Application for a non-material amendment following a grant of planning permission.
Town and Country Planning Act 1990

Erection of 2 detached bungalows

Reference number:H23-1318-16

Old plan/drawing numbers: PD101(P1)

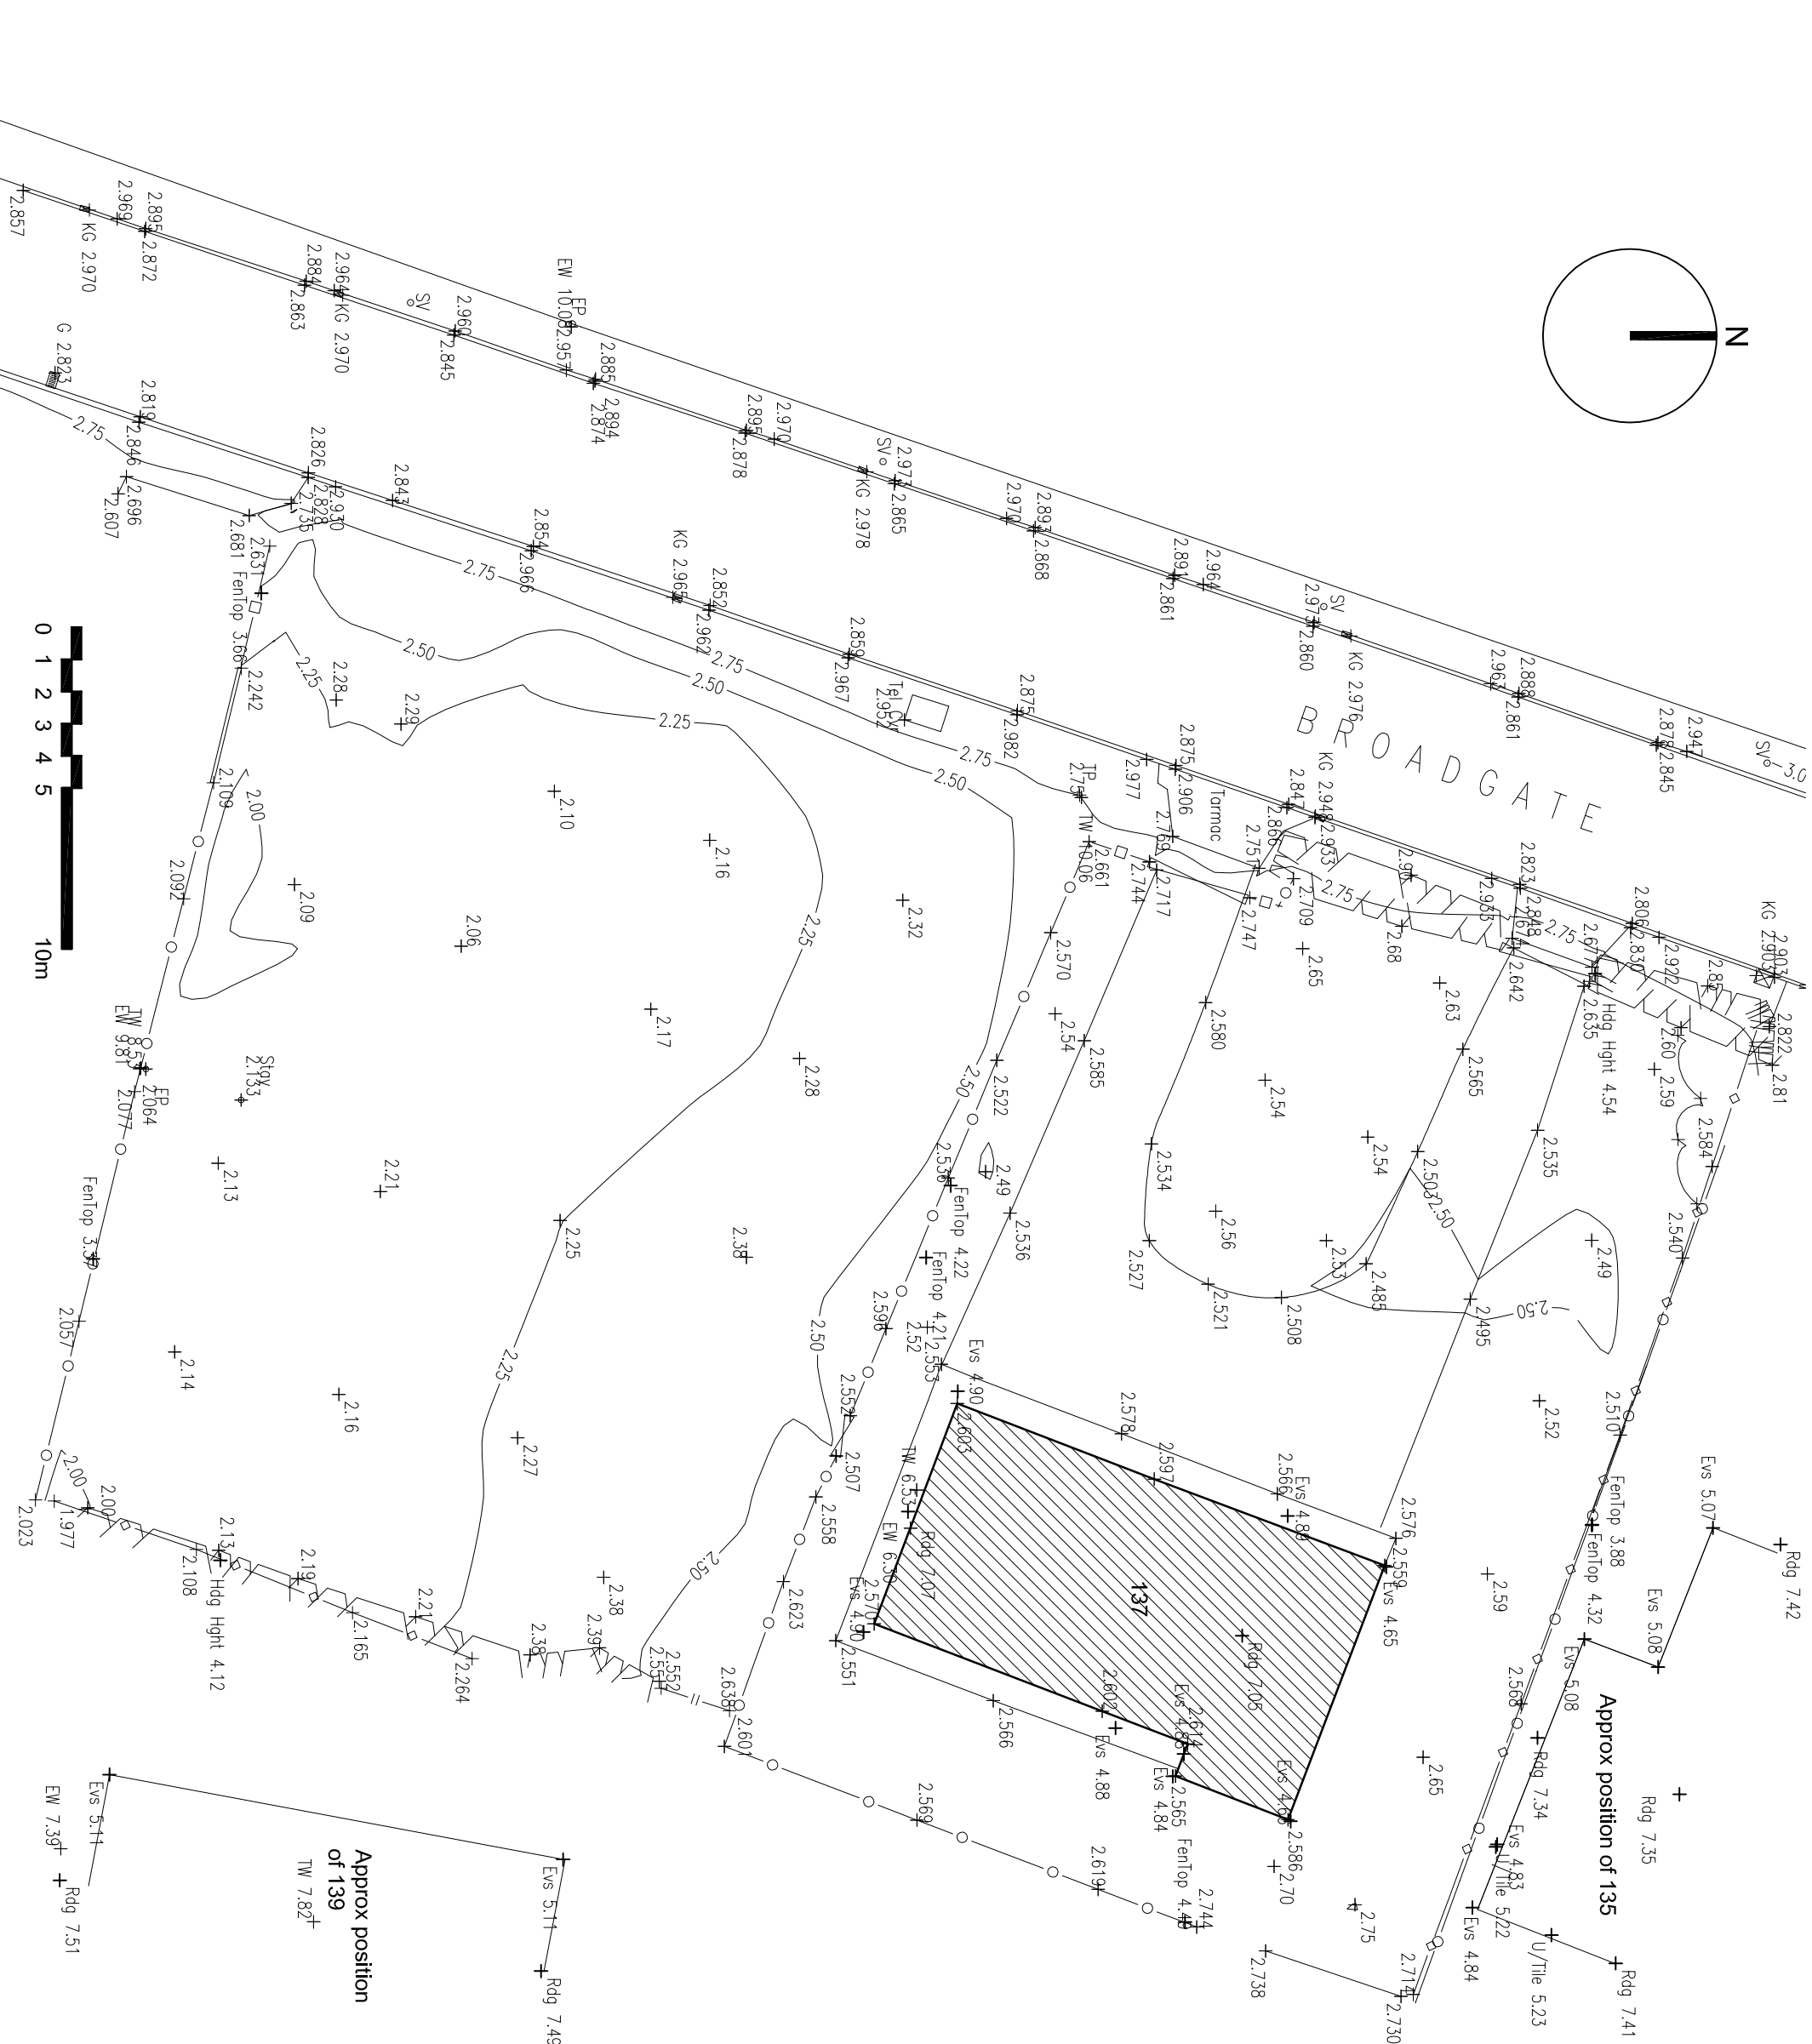
Revise side elevations - removal of integral porch to front door and removal of en-suite window and enlargement of bathroom window.

Revise driveway adjacent front door and garage to omit area of gravel and substitute with permeable block paving (brindle colour).

The applicant has omitted the en-suite bathroom in lieu of a larger bathroom.
The applicant does not require a porch to the front door.
The permeable paving enables the ramp to the front door and to the garage entrance to be better integrated.
